Engineers Comments Regarding Surface Water Drainage

Application Reference:	WA/33/26/PL	Reviewer Reference:	ADC/EXT5/AF
Planning Officer:	Hebe Smith	Date of Review:	22/05/2026
Site Name:	The Greenway, West Walberton Lane, BN18 0QS		
Application Description:	Construction of a self-build/custom build single dwelling, with garage outbuilding and associated works.		
Assessment Number:	1

**Land north of The Green Way
Appendix 5 - development proposal plan**

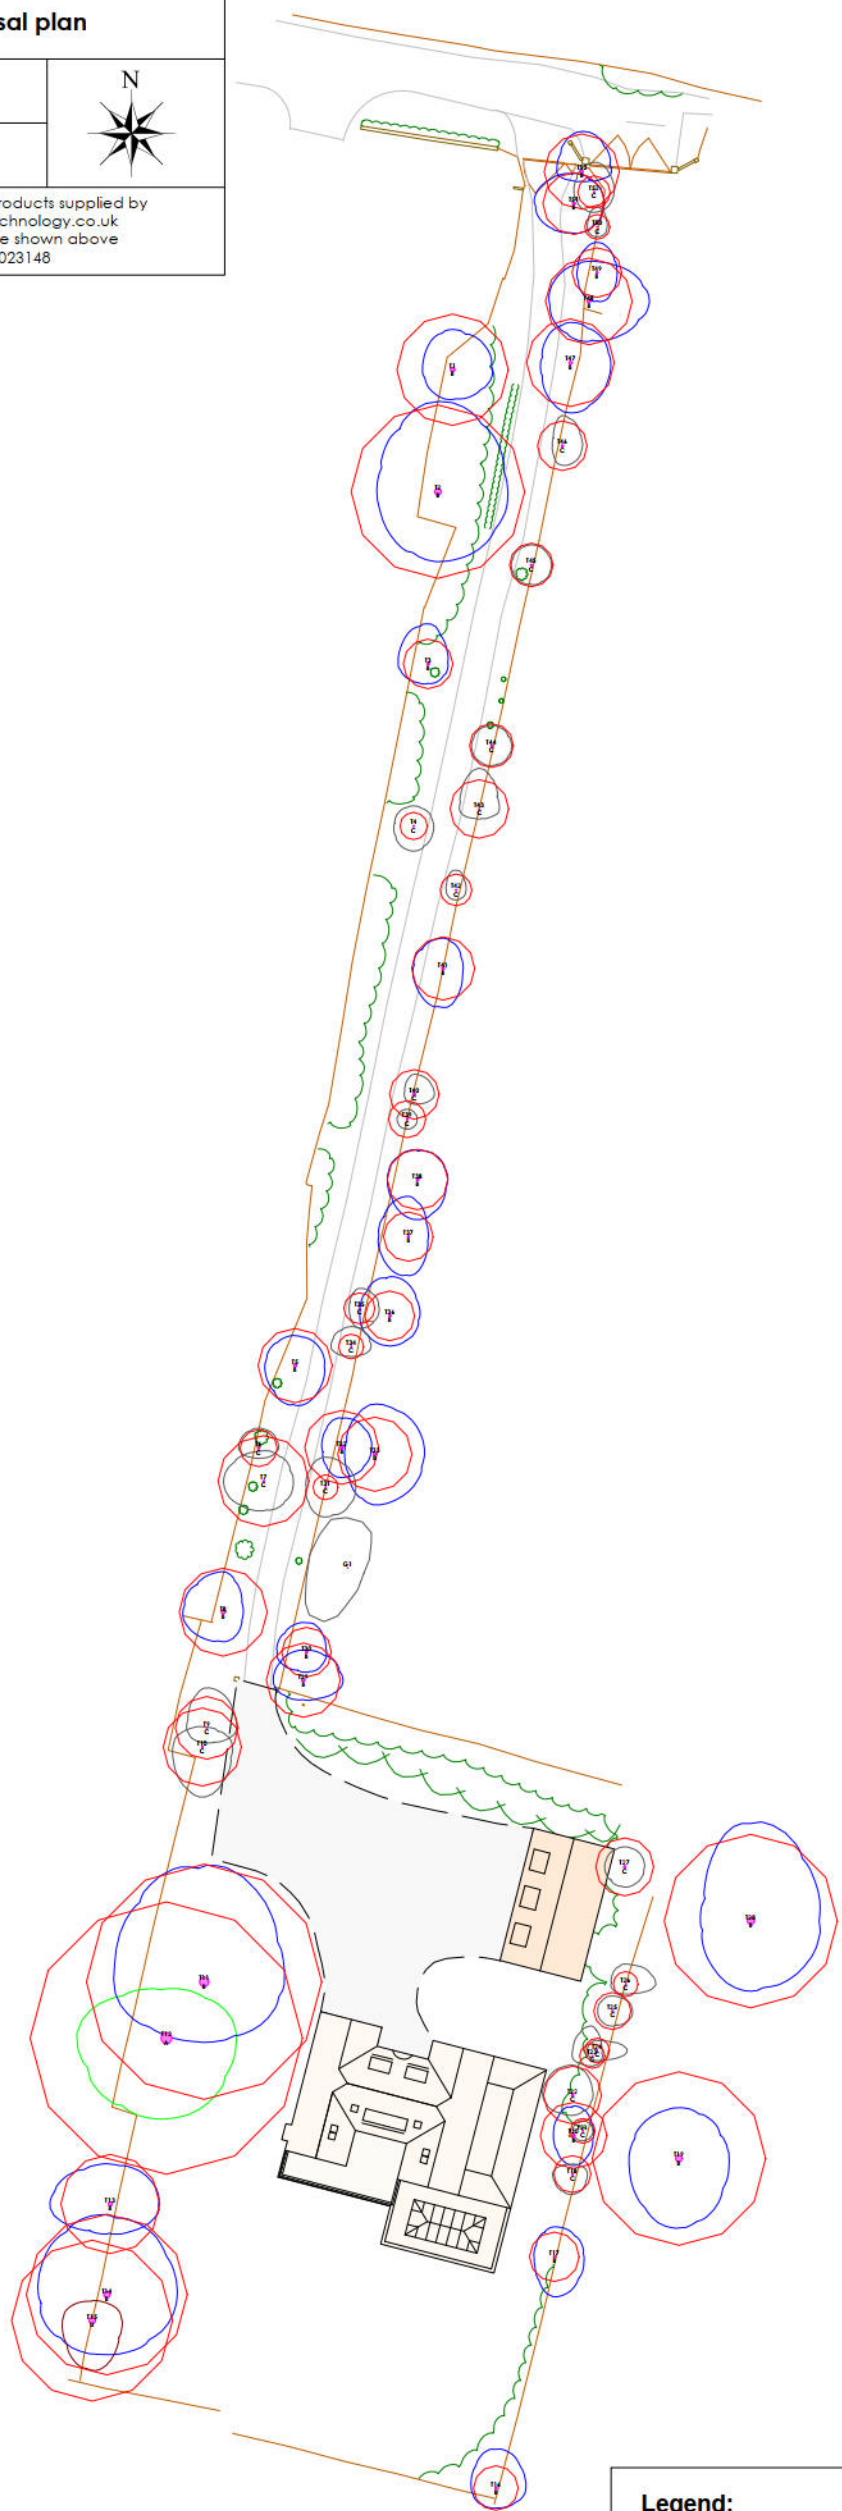
- 0.4. The existing trees on the eastern side of the access drive have root protection areas that conflict with the proposed permeable paving. It is also noted that root protection measures may significantly encroach within the root protection areas of some trees along the eastern boundary of the site. The Planning Officer may wish to consult the Arboriculture Officer for their views on this matter.

- 3.5. Please provide clarification as to how the permeable driveway with existing trees is designed and included in the drainage calculations in terms of how the storm water will be stored whilst retaining root protection areas which typically require 'no dig' construction.
- 3.6. The design does not currently meet the requirements of Standard 3 of the NSfS, therefore we **Object** to the application. The objection may be able to be removed once further information is reviewed.

Land north of The Green Way
Appendix 6 - tree protection plan

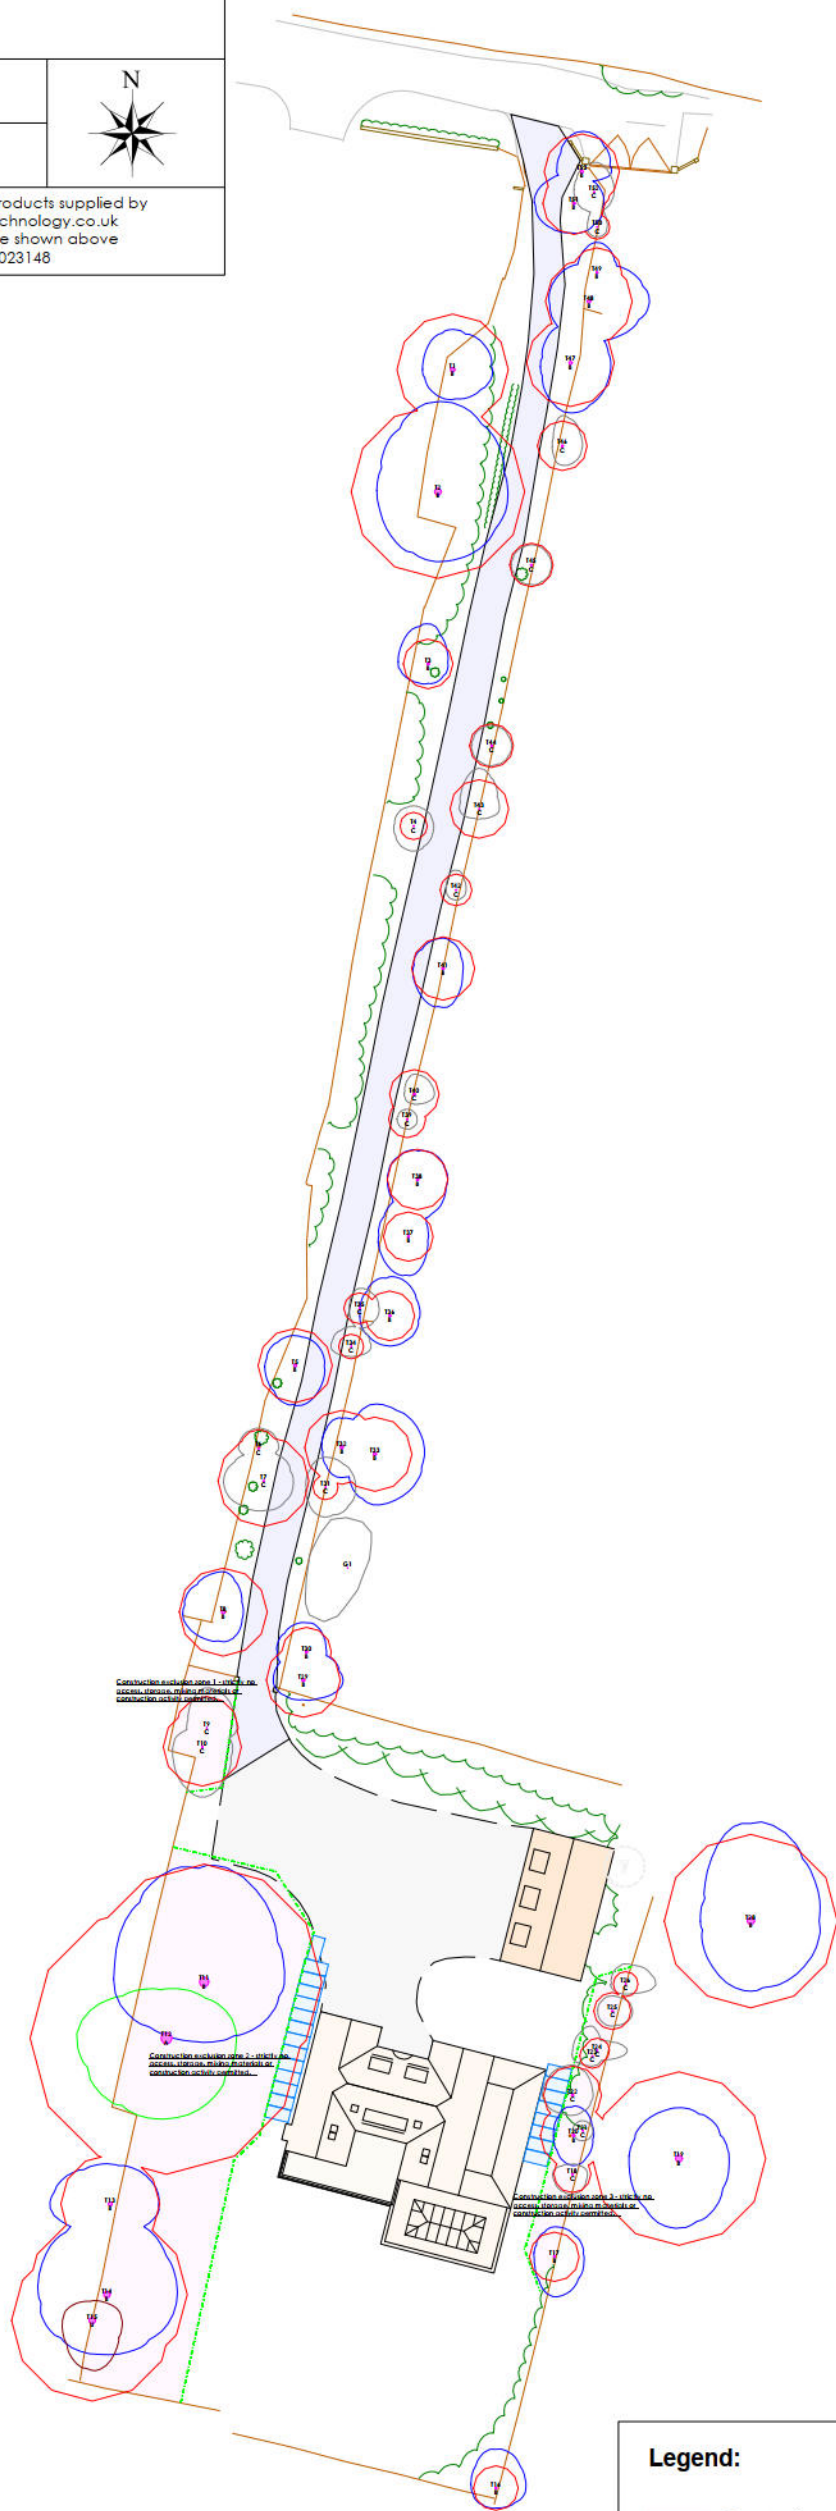
- 7.1. An outline maintenance plan is provided which is proportionate to the scale and nature of development as the dwelling will be in a single ownership.
- 7.2. There are a significant number of good quality trees on the site, most of which are to be retained. These existing trees are a constraint to the drainage strategy as any drainage installations should not damage the trees, and the drainage infrastructure itself needs to be protected from tree root damage. The design as submitted demonstrates areas of conflict with the existing trees and their current root protection areas which will require root protection construction methods.
